Botley West Solar Farm (Ref: EN010147)

Rule 17 letter dated 17th June 2025 [PD-009]

Joint response from the Host Authorities

1st July 2025

Representative Viewpoint 25: View looking south from footpath 238/5/20

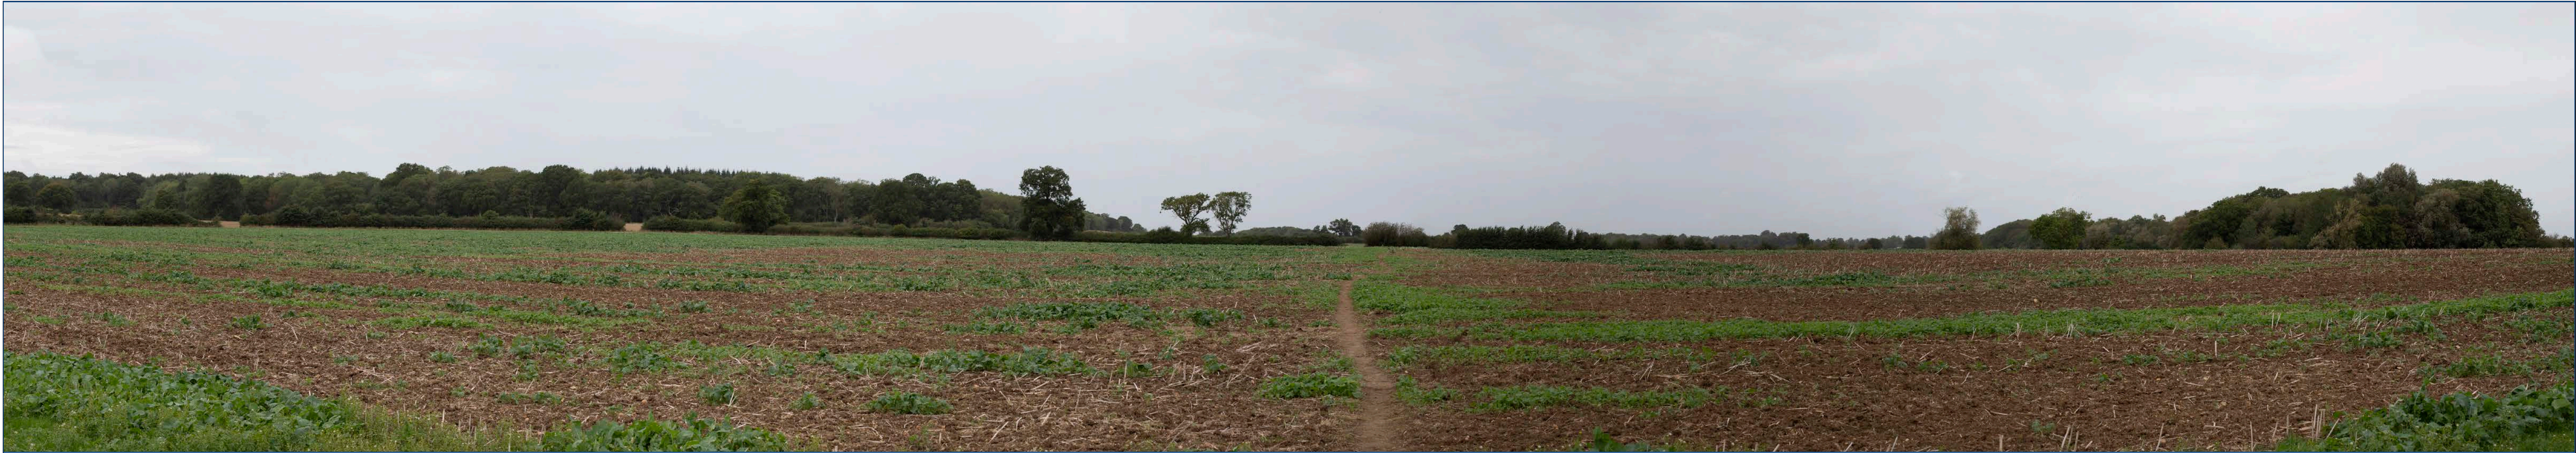
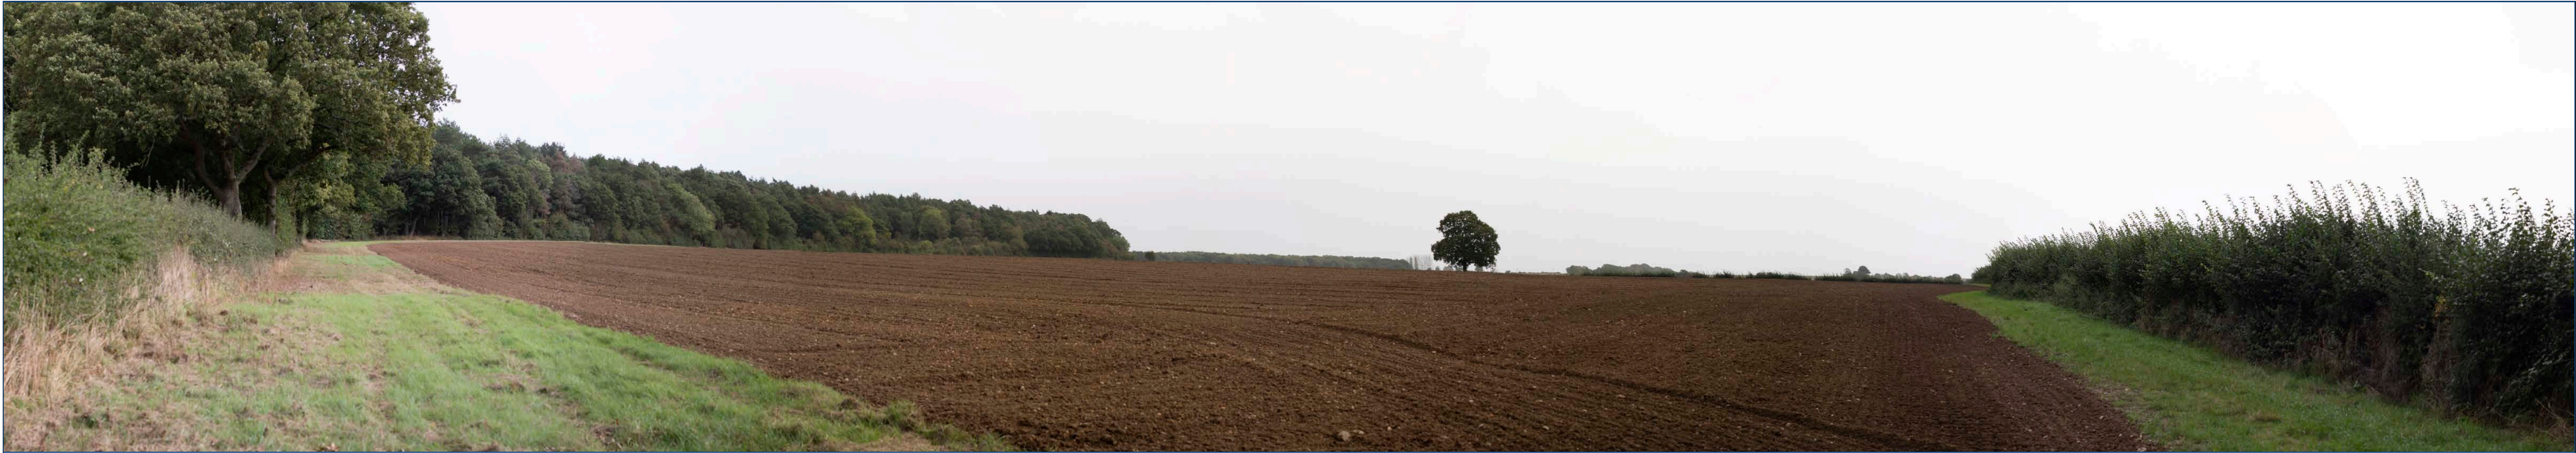
Assessed as having a moderate to major adverse effect during the operational phase at winter year 1 which reduces to a *moderate adverse* effect at summer year 15. This is based on a

medium level of impact for a receptor of *high* sensitivity. This viewpoint is in an elevated position and offers panoramic, long-distance view of the surrounding countryside. It could be argued that the magnitude of impact from this location should be assessed as *high* due to the dominance of the proposed development in the landscape and the substantial change in view. The proposed mitigation planting would also result in a change to view by screening the panoramic views of the surrounding countryside, although the proposed development would still be visible in near and long-distance views. WODC consider that even with proposed mitigation the residual impact in this location is more likely to be *moderate to major*, which is significant.
